Our ref: DOC20/526659
Senders ref: SSD 10291

Subject: Notice of Exhibition – St Luke’s Grammar School Senior School Campus, 210 and 224 Headland Road and 800 Pittwater Road, North Curl Curl (SSD 10291)

Thank you for your e-mail dated 3 July 2020, inviting Environment, Energy and Science Group (EES) in the Department of Planning, Industry and Environment (DPIE) to comment on the Notice of Exhibition for St Luke’s Grammar School Senior School Campus, 210 and 224 Headland Road and 800 Pittwater Road, North Curl Curl.

DRAWING TITLE		DRAWN BY	
224 HEADLAND ROAD		RM + CE + EG	
LEVEL 0 DEMOLITION PLAN_224		CHECKED	PT
SCALES AT A1		DATE	March 2020
PHASE		REV	A
SSDA	DRAWING NO	A-040

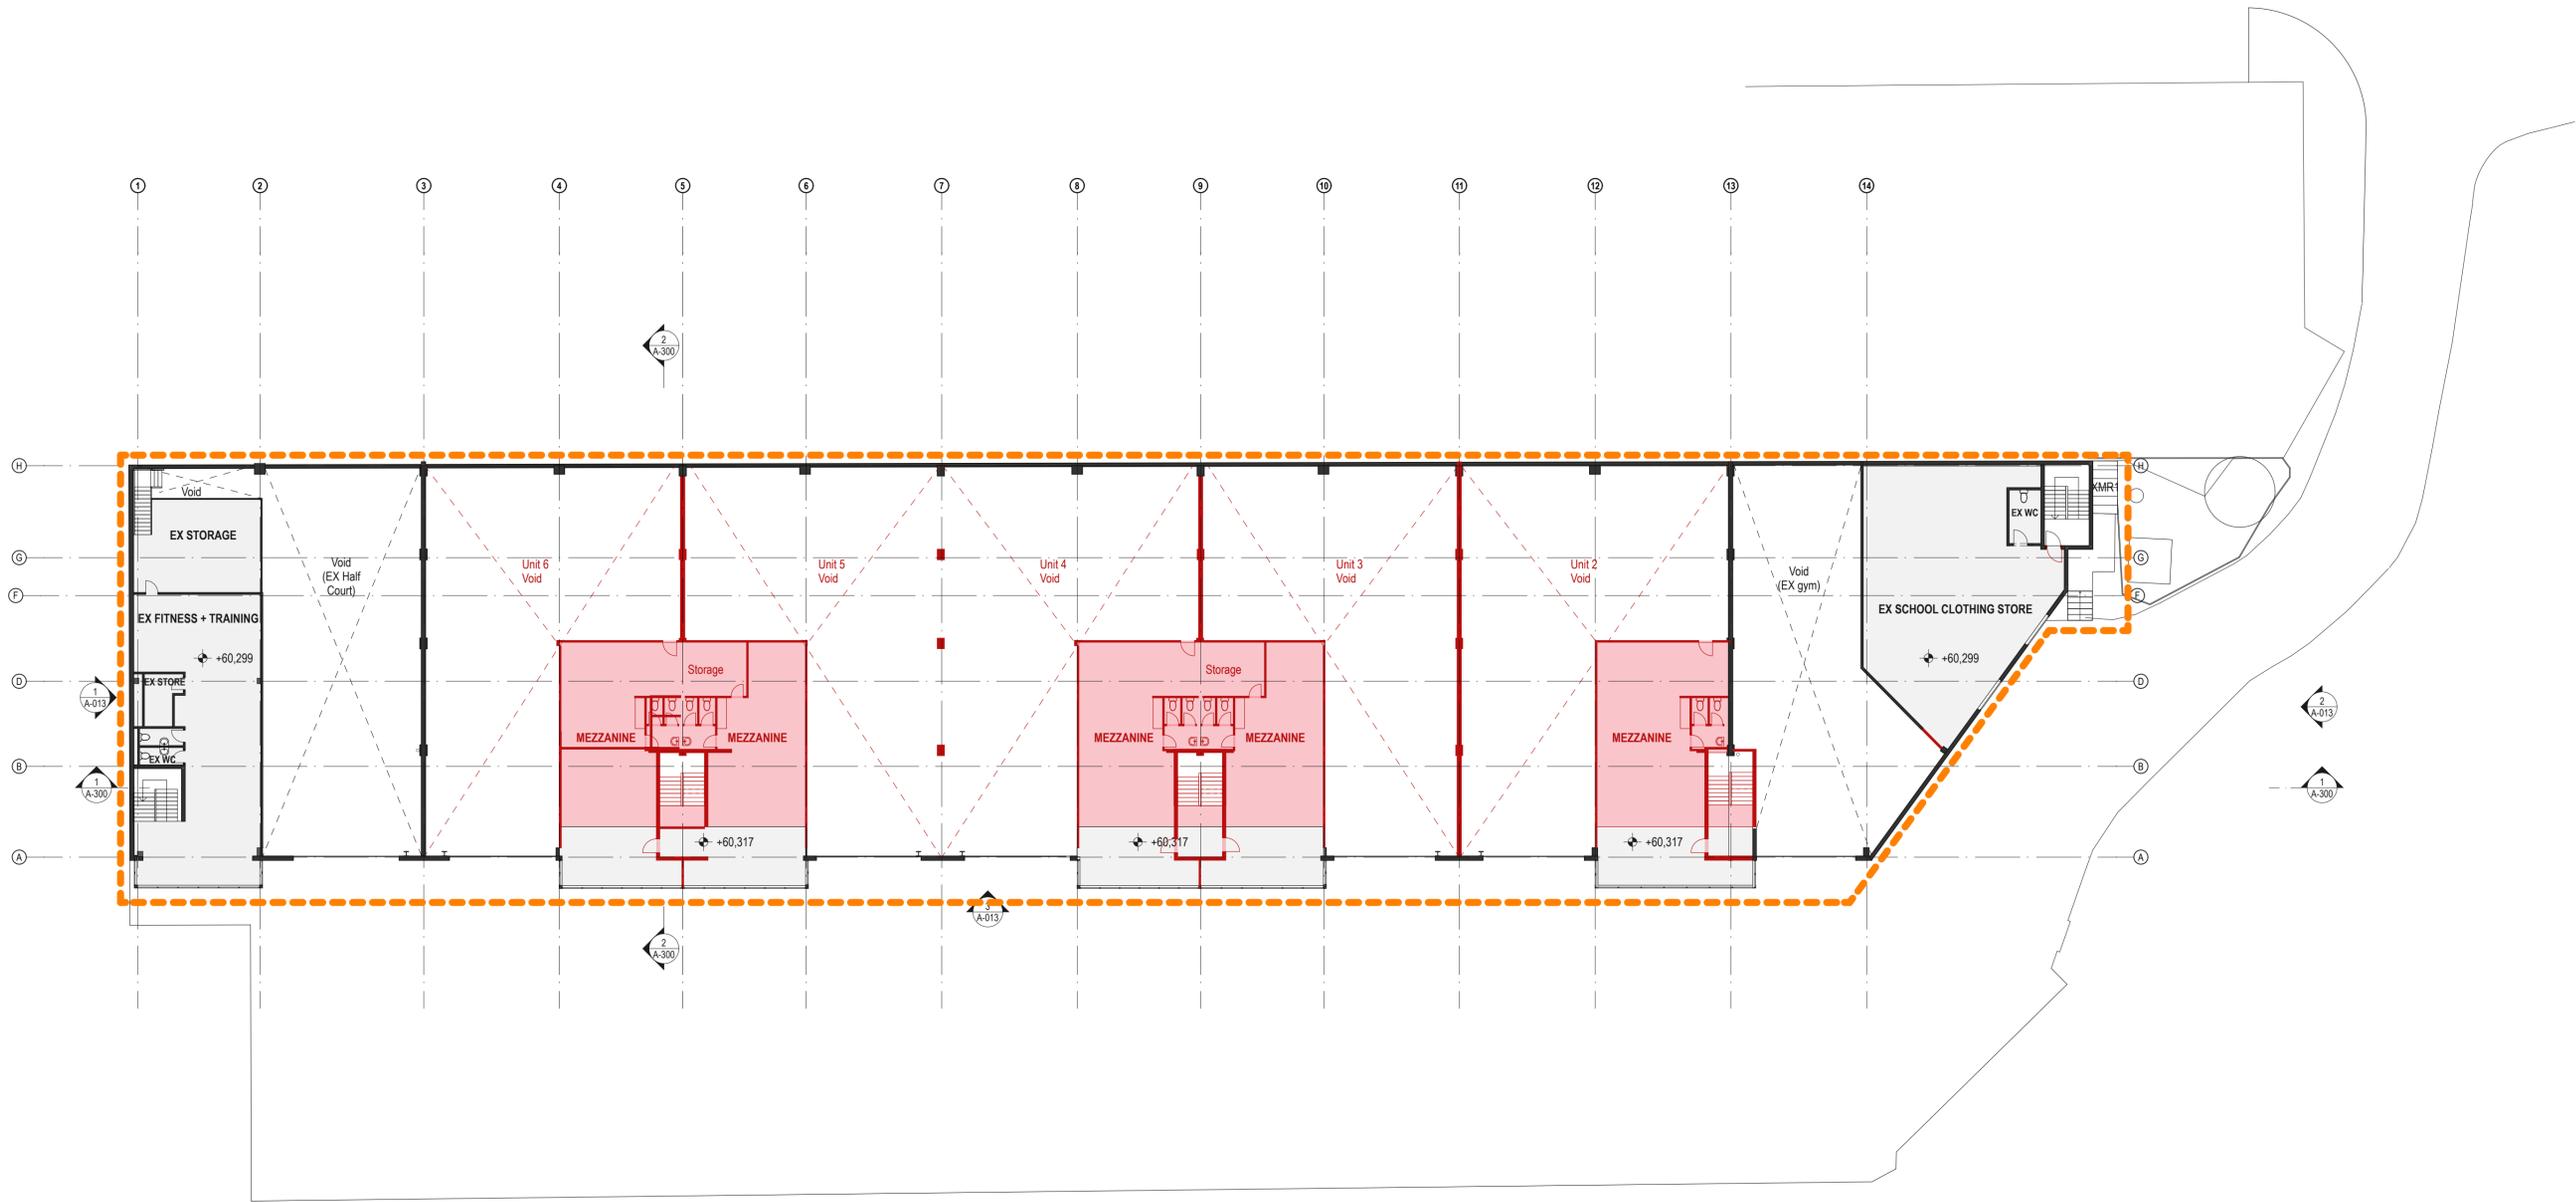
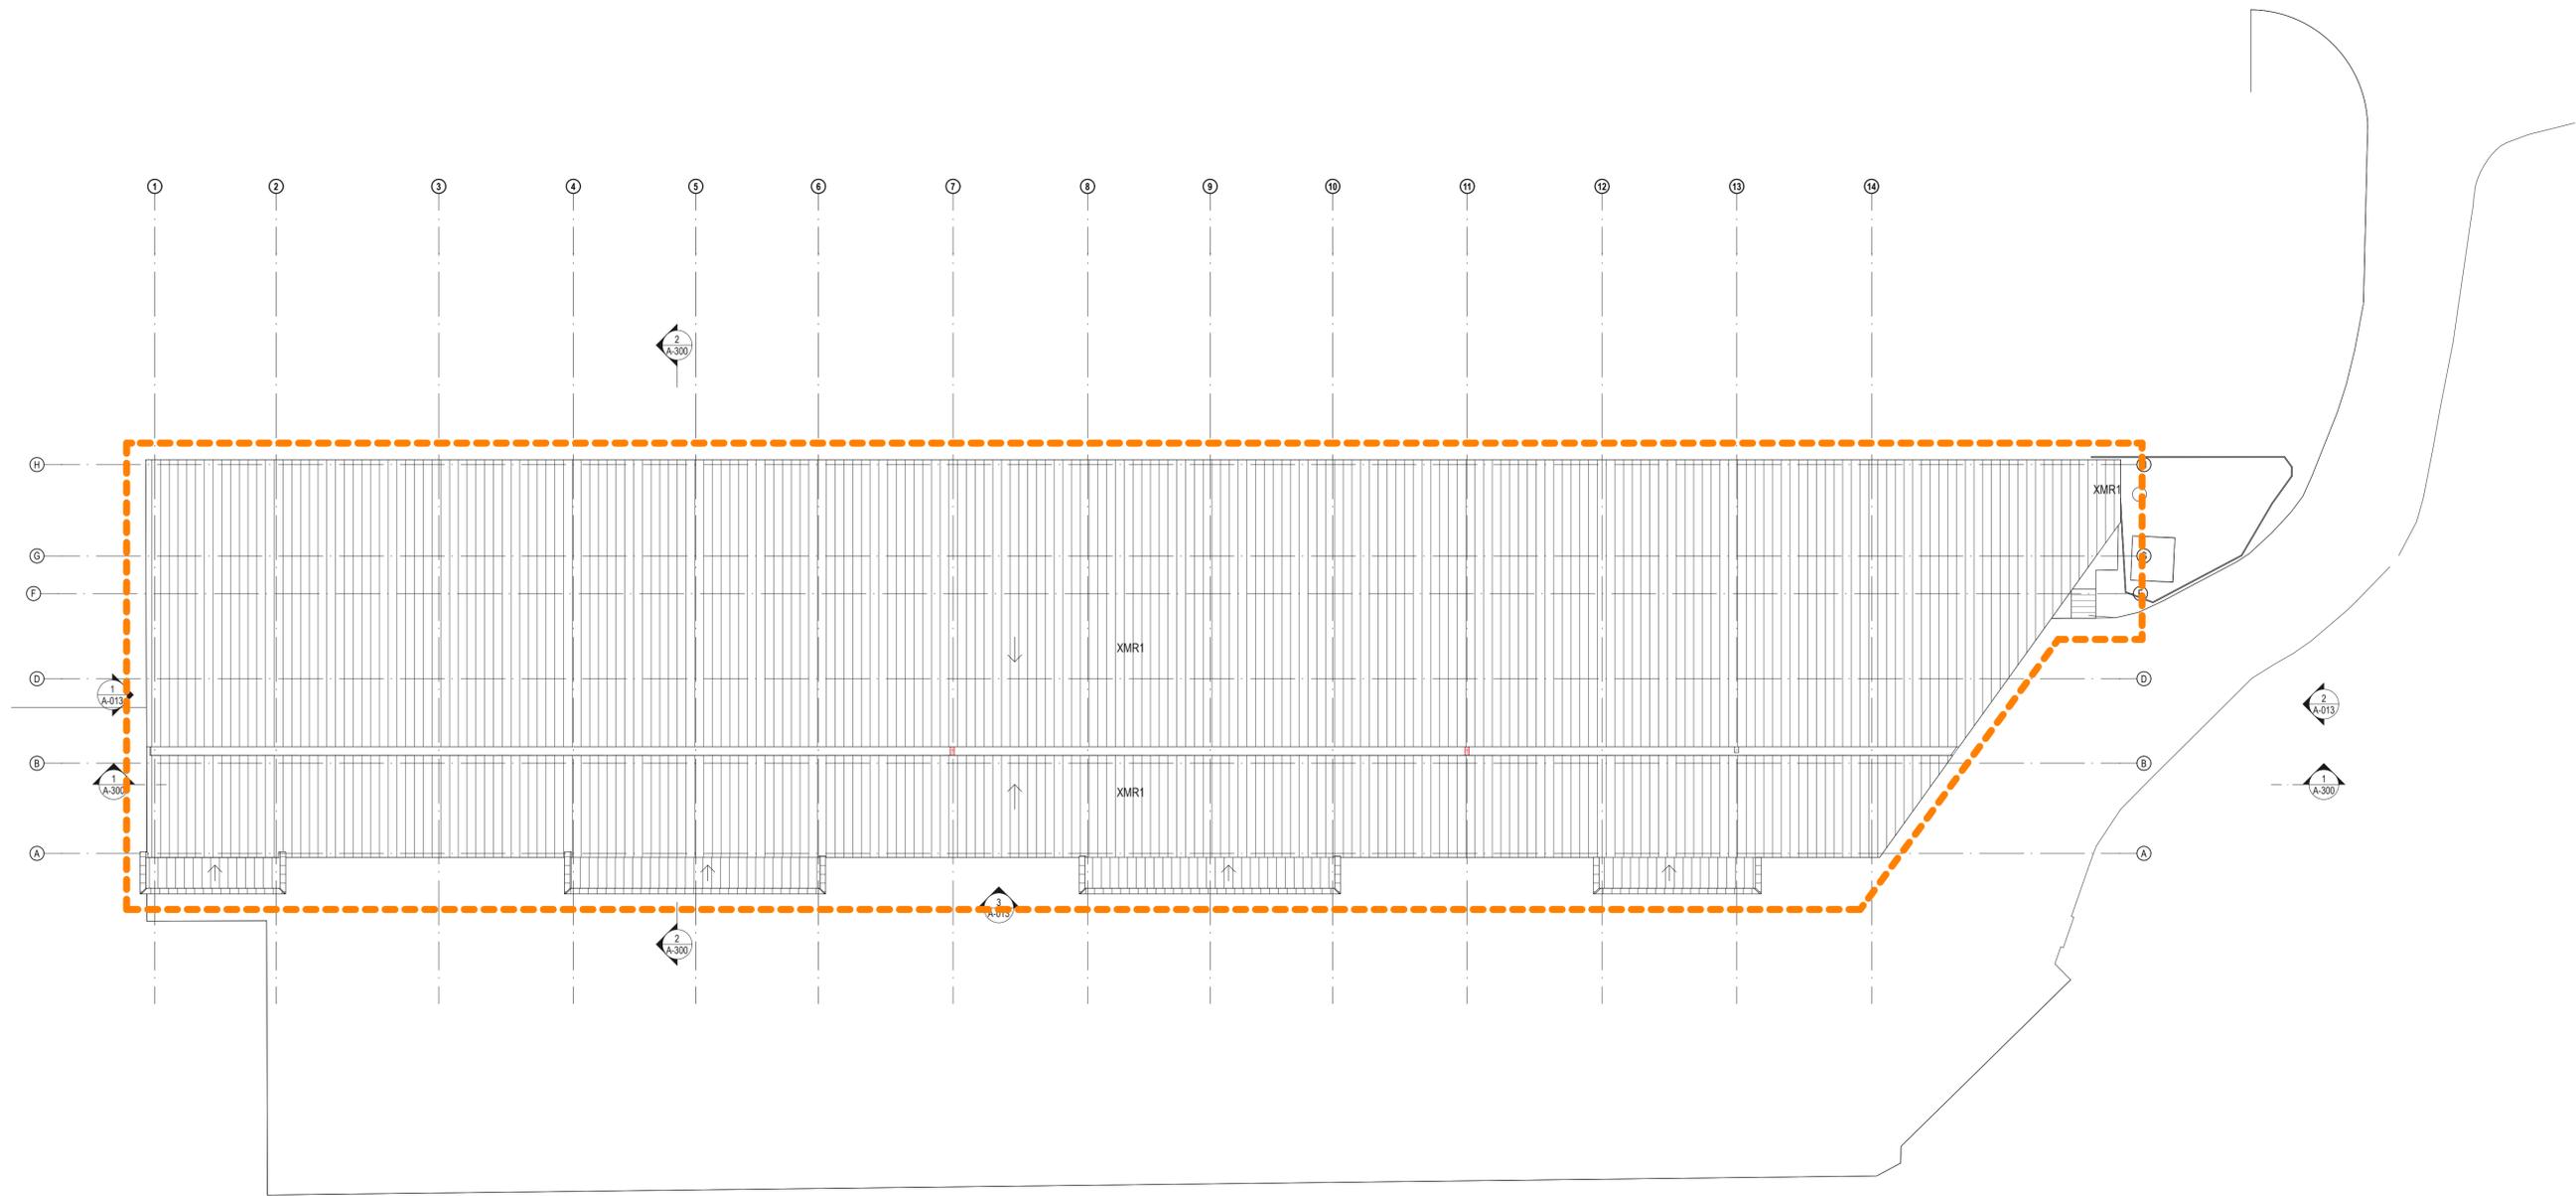
Part of the SSD is at 224 Headland Road, on which existing structures consist of a large concrete platform on which is situated a multi-storey commercial building, oriented north-south, and an open carpark. On its eastern side the platform is supported on an elevated sandstone outcrop, but its western side and northern end extends out from and above the outcrop supported by large columns. This configuration situation provides for an area with numerous cavities and crevices of varying size, in parts sheltered by vegetation. The southern two-thirds is also sheltered by the closely proximate commercial building to the west. These features are illustrated by photographs in Figures 51, 52, 58 and 59 of the Heritage Impact Statement (City Plan Heritage).

The measures in Table 21 titled “*Measures proposed to mitigate and manage impacts*” should be revised to consider the possibility that microbats might be encountered in such structures, not just in trees.

EES recommends that measures such as inclusion of pre-clearing surveys, daily surveys and staged clearing, and the presence of a trained ecological or licensed microbat wildlife handler during clearing events, should apply to demolition of existing structures, not just to clearing of trees, as is currently proposed.
